PLANNING AMENDMENT

H22/1119/96
16 JAN 1997
JRS

SITE FOR CONSTRUCTION OF
A NEW VILLAGE HALL

REVISED PRELIMINARY STUDY FOR LOCATION OF BUILDING

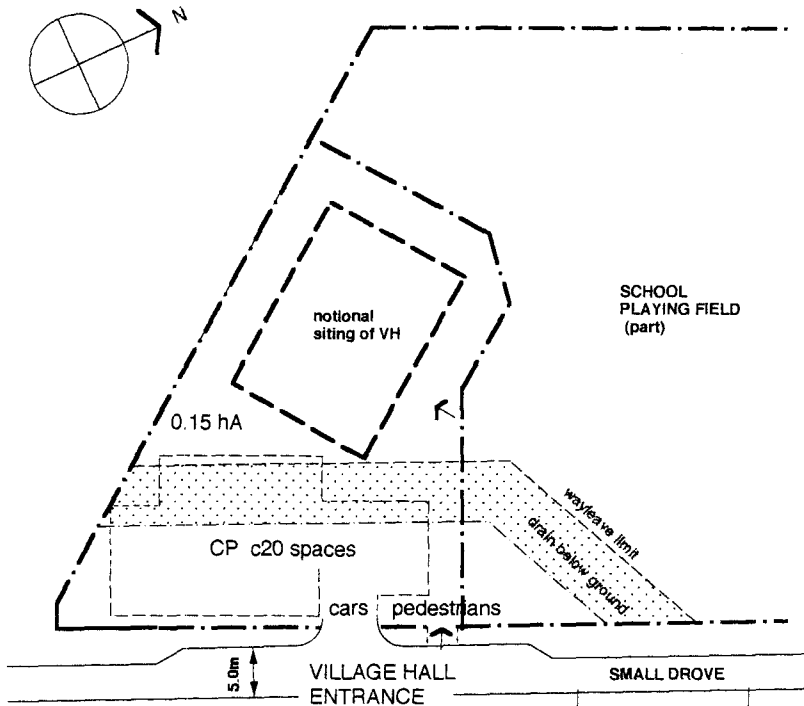
NO NUMBER / ENTITLED "REVISED PRELIM.
STUDY FOR LOCATION OF BLDG"

SITE PLAN SHOWING LOCATION OF BUILDING & CP

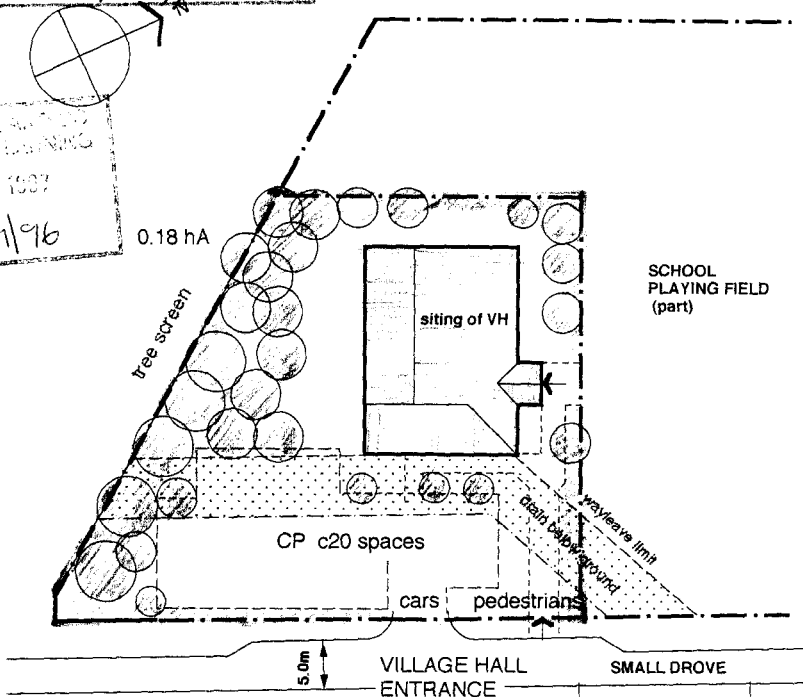
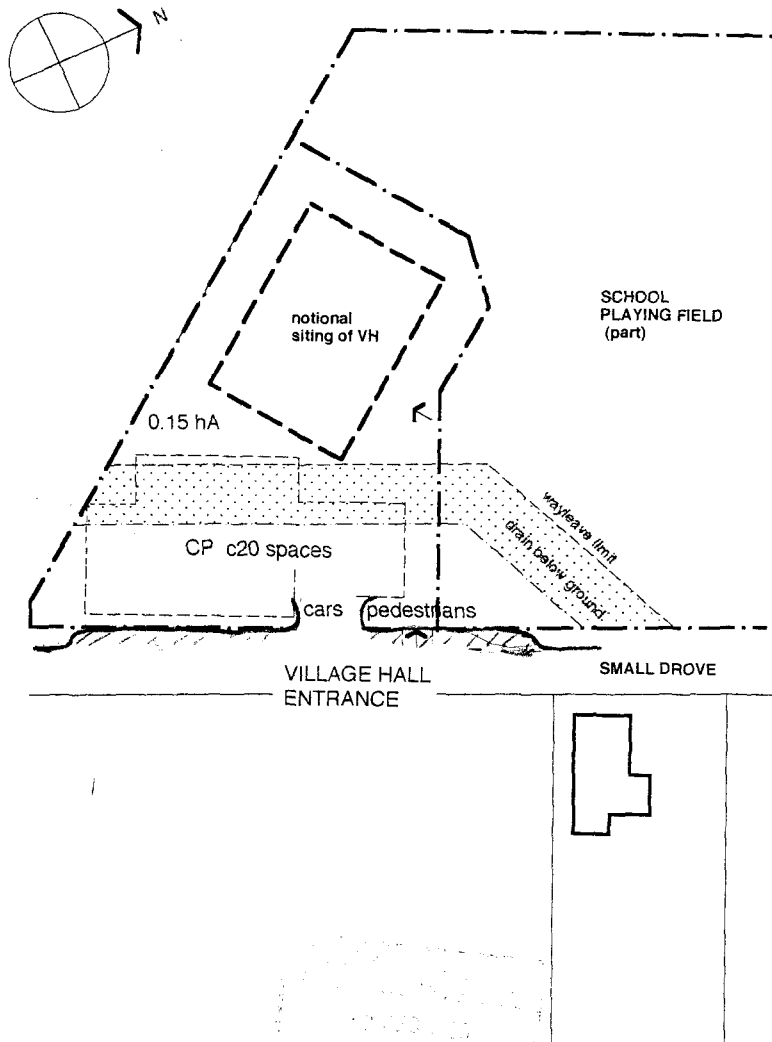
RETHAPING OF SITE BOUNDARY
AND RELOCATION OF LOCATION OF
HALL AND CAR PARK
